# Rezoning Transportation Analysis

Petition Number: #2022-106

## Revision Log:

Date	Description
11-28-22	First Review (TM)

**REZONING SITE PLAN**

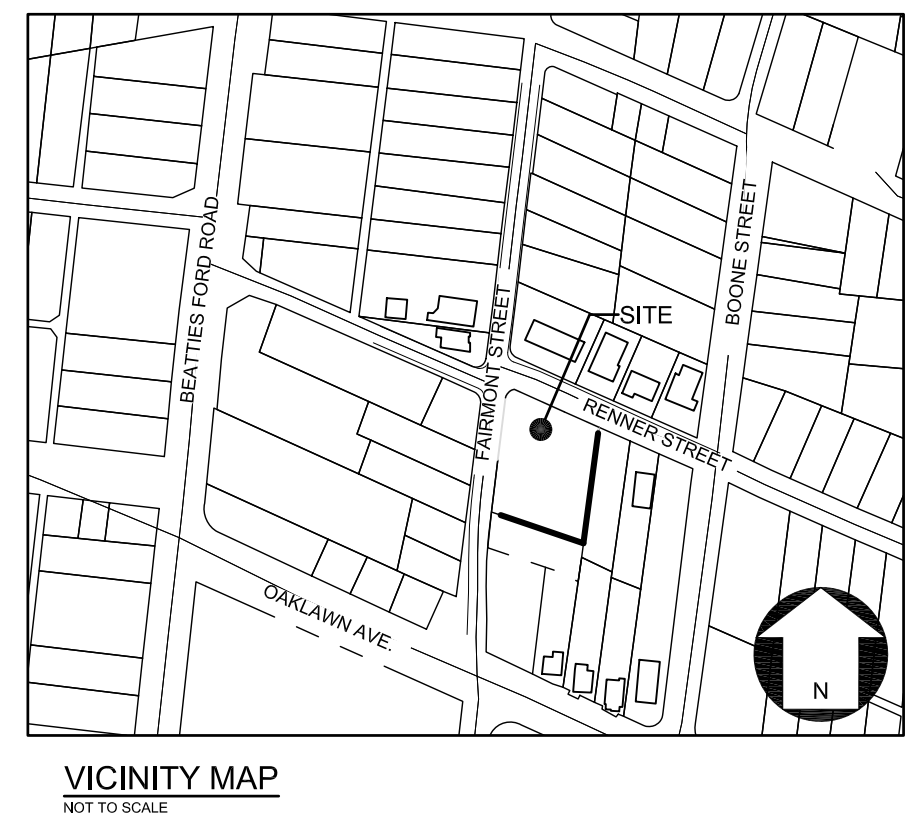
1. **Curblines:** The proposed zoning district has a setback measured from back of the existing or proposed future curblines.
  - a. **Renner Street:** Location of curb and gutter needs to be coordinated with CDOT.

Label and dimension the curb and gutter from the centerline for each road on the site plan.

3. Revise site plan and conditional note(s) to commit to dedicate 28-feet of right-of-way from the road centerline. The site plan shall label and dimension the right-of-way from the road centerline.

4. Revise conditional note(s) to commit to construct an 8-foot planting strip, and 8-foot sidewalk on Renner Street and Fairmont Street per Chapter 19. The site plan shall label and dimension both items from the back of curb and gutter and road centerline.

5. Site plan and conditional note(s) revisions are needed to commit to dedicating ROW in order to realign the existing intersection of Renner Street and Fairmont Street. Realignment of Renner Street at the intersection to be coordinated with CDOT.

6. A site plan note(s) specifying dedication and fee simple conveyance of all rights-of-way to the City before the site's first building certificate of occupancy is issued as needed. CDOT requests rights-of-way set at 2' behind back of sidewalk where feasible.

7. A site plan note specifying that all transportation improvements will be approved and constructed before the site's first building certificate of occupancy is issued as needed. The petitioner may phase transportation improvements if said improvements and phasing are explicitly described in site plan notes.
